From: Rhiannon Lloyd
Sent: 29 May 2026 10:45
To: Planning.Responses
Subject: Fw: EP/43/26/PL
Attachments: 02B Proposed A1.pdf

I hope you're well, please could you substitute the current proposed drawings with the one attached for the above mentioned project. This simply includes a minor tweak to the east elevation from brick to render.

North Elevation
1:100

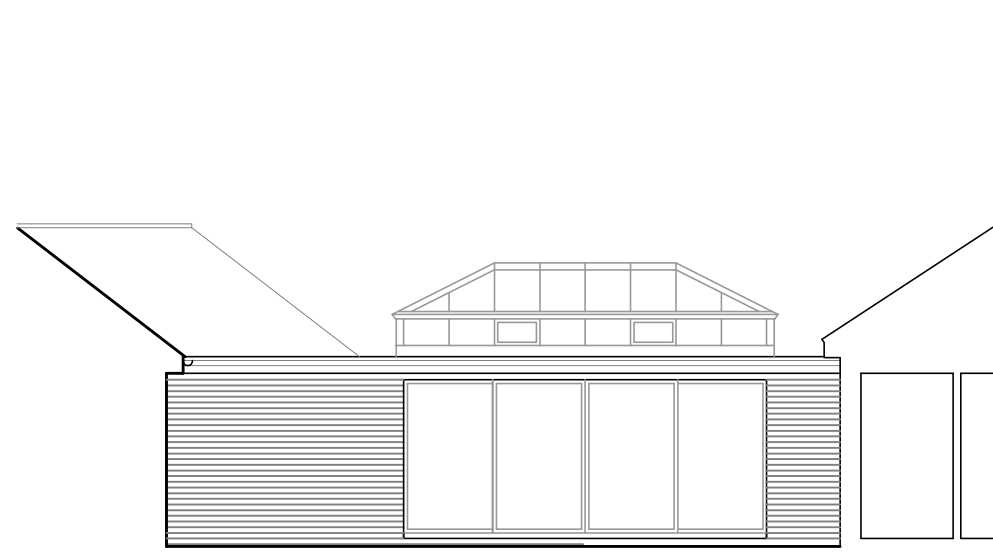
I have attached an annotated existing floor plan and elevations for the above site.

I may be having a bad day, but I think with the North point, the North elevation should be labelled South elevation?

I believe the elevations are labelled correctly in that they should be labelled the direction in which they are facing, please feel free to give us a call if needs be.
